FLYING HORSE NORTH FILING NO. 5 CONSTRUCTION DOCUMENTS

FLYING HORSE NORTH FILING NO. 5
PRI #2, LLC.
EL PASO COUNTY, CO

COVER & LEGEND
COVER

**SHEET  
 SP  
 3**

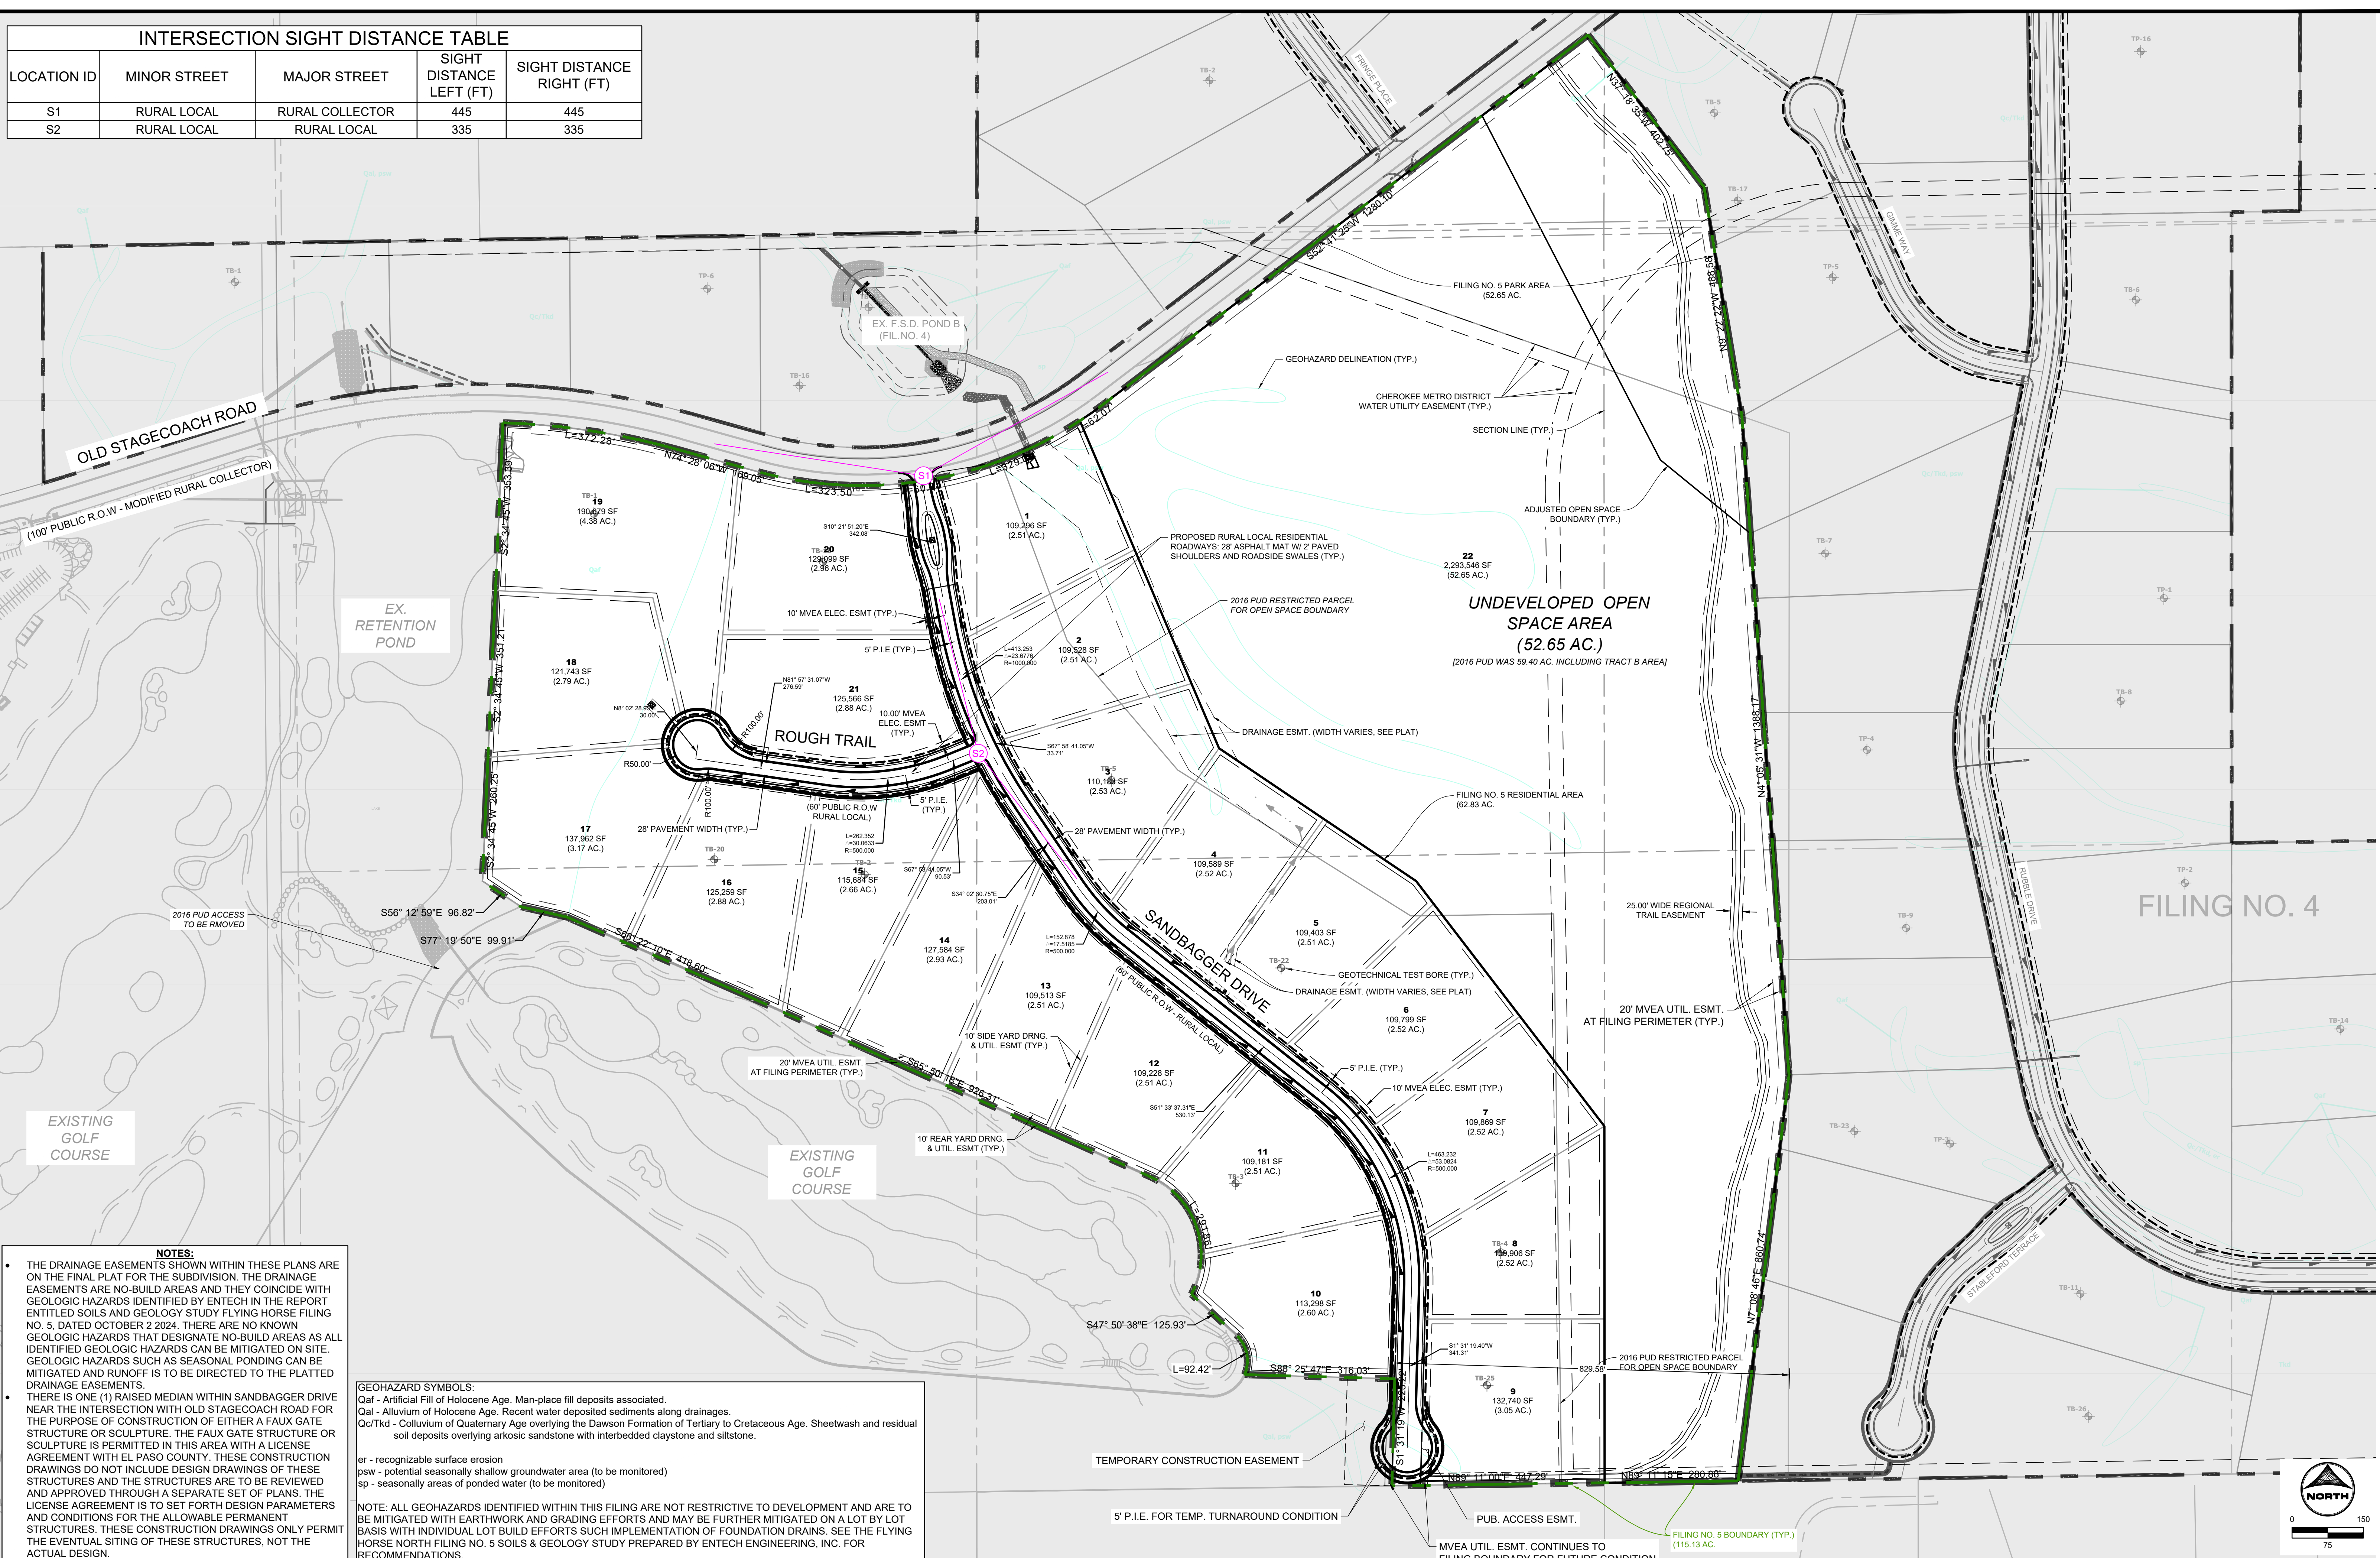
Please show and label radius of cul-de-sacs

Please show and label drainage easement.

Please include legend for all line types

28' per detail

5' public improvement easement on each side of the proposed roadway ROW is required.

Exceeds the length for a temporary CDS; This will require a deviation request

SHEET  
**ST**  
**4**

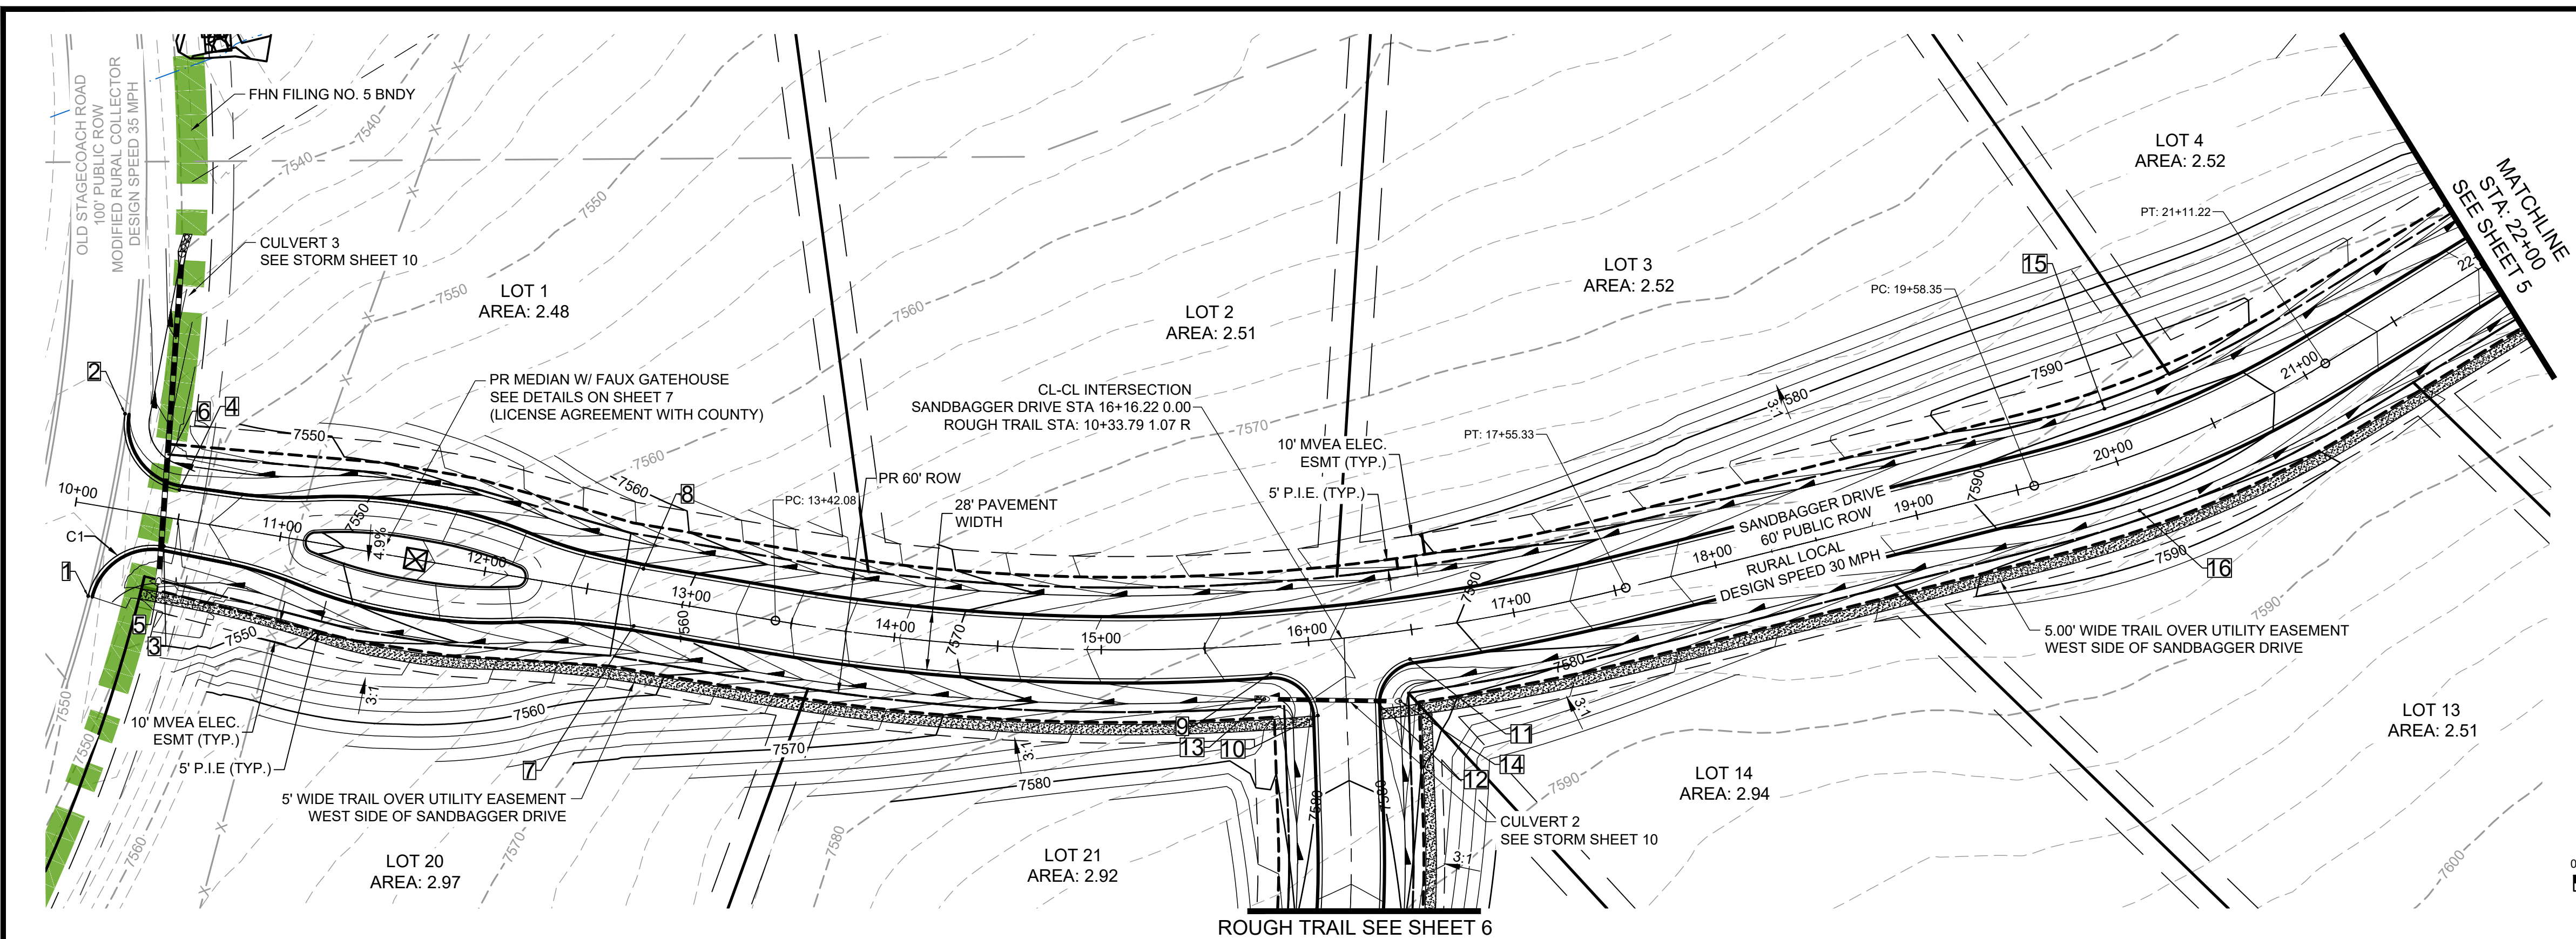
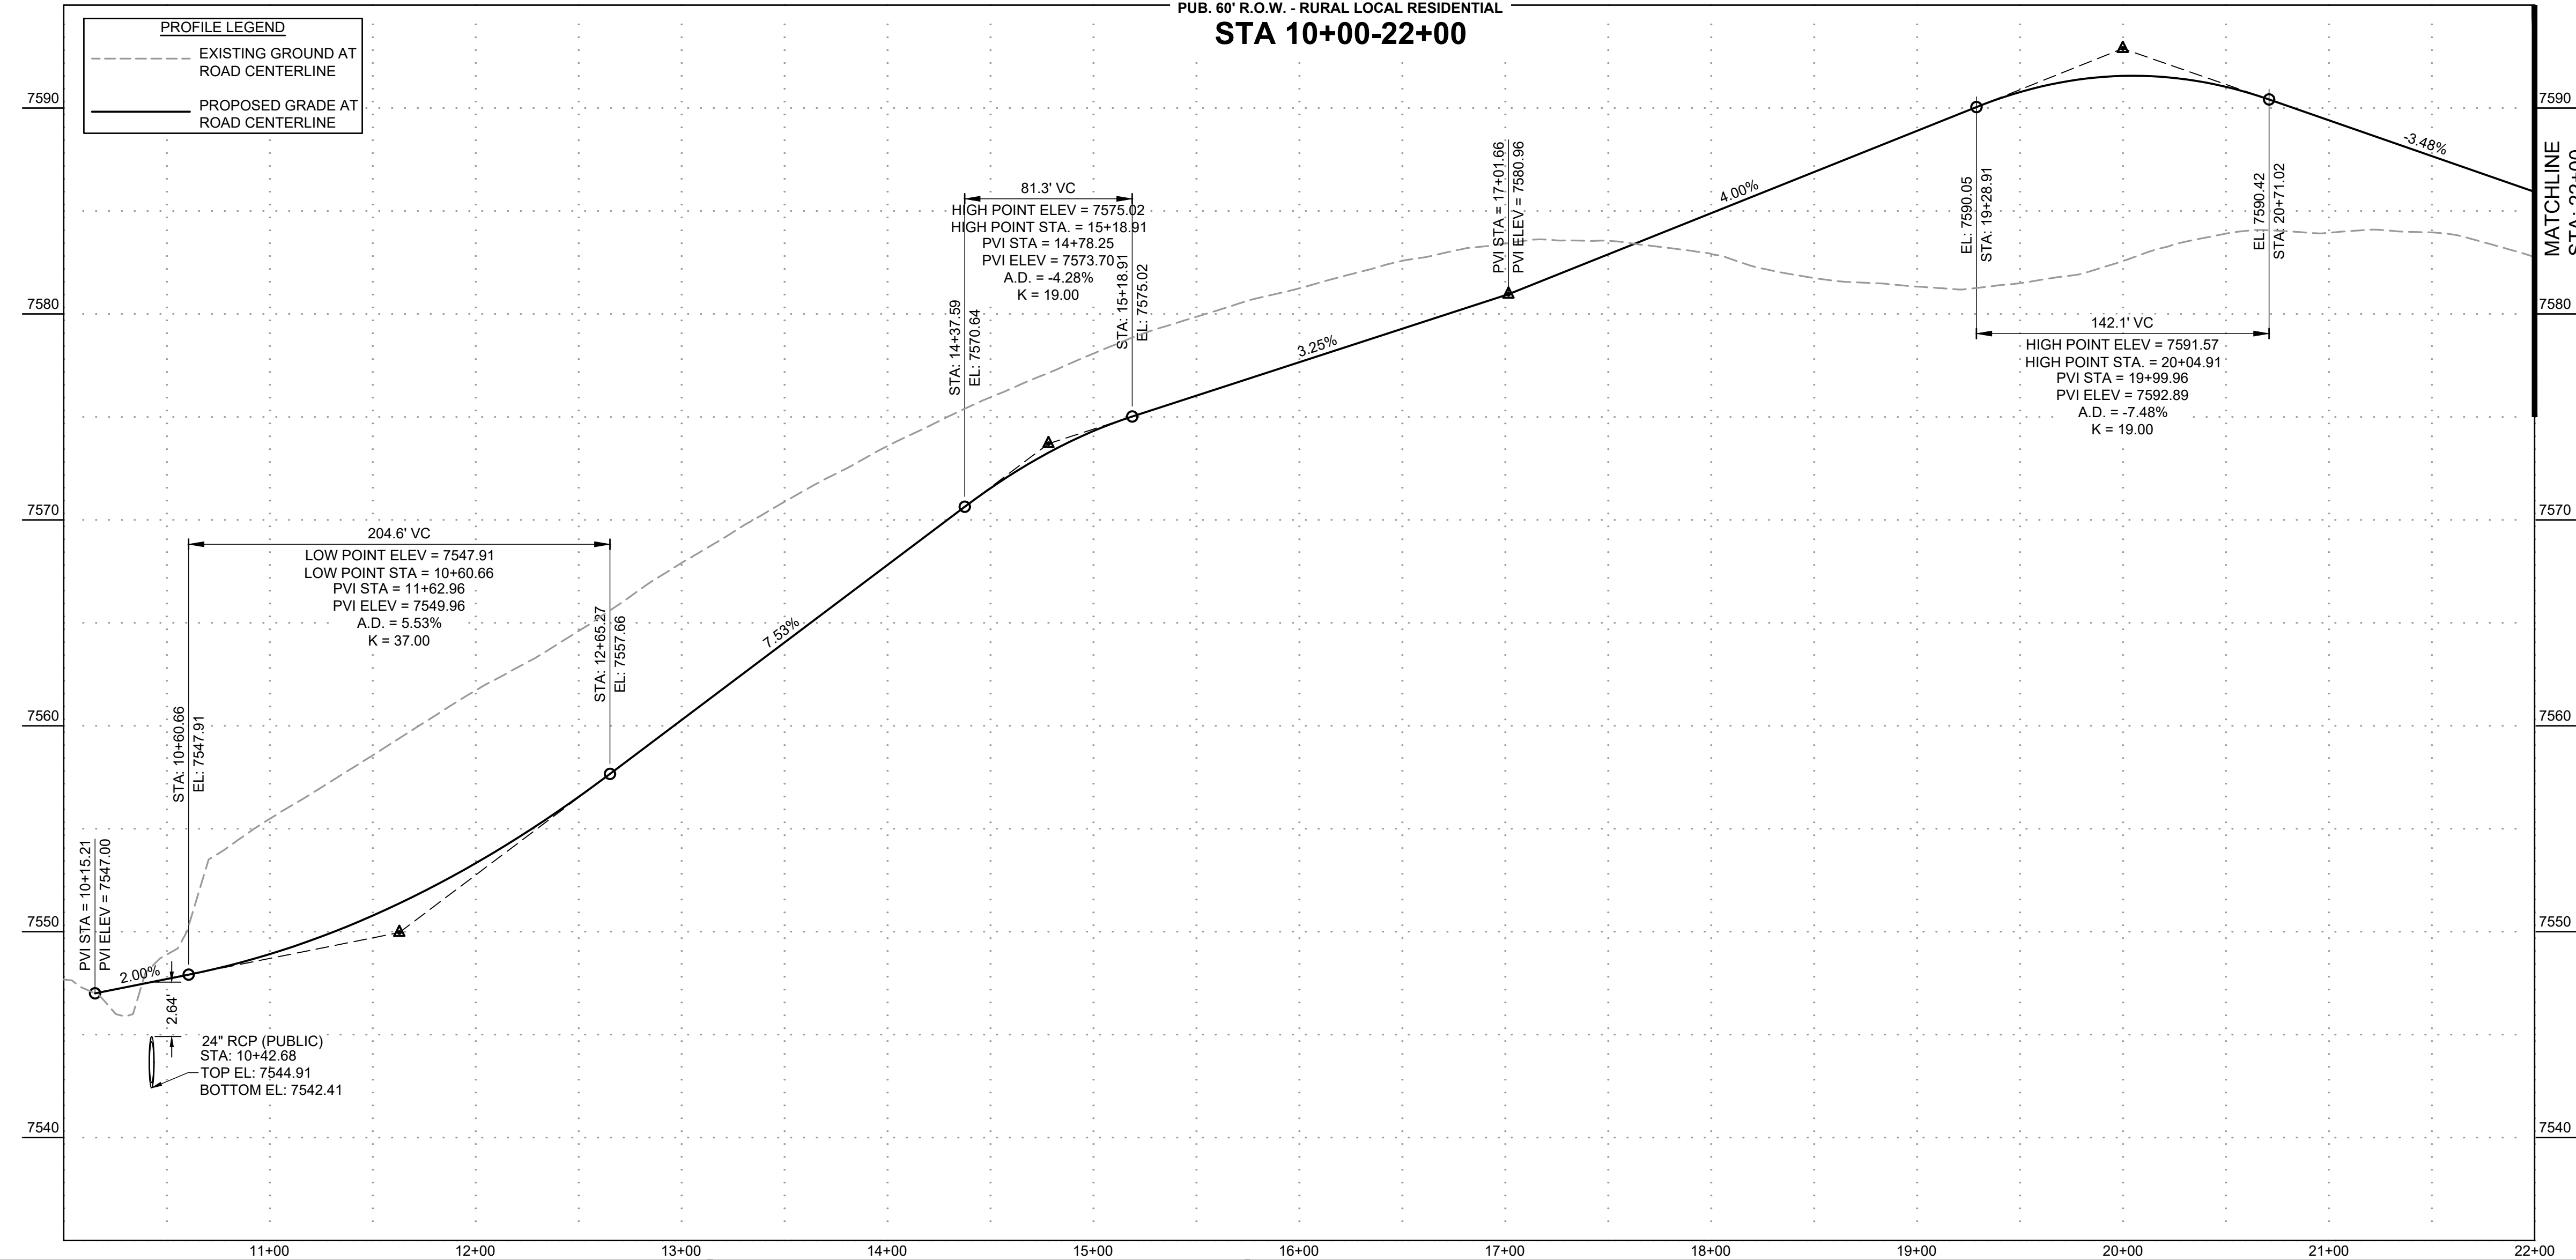
Revise stationing
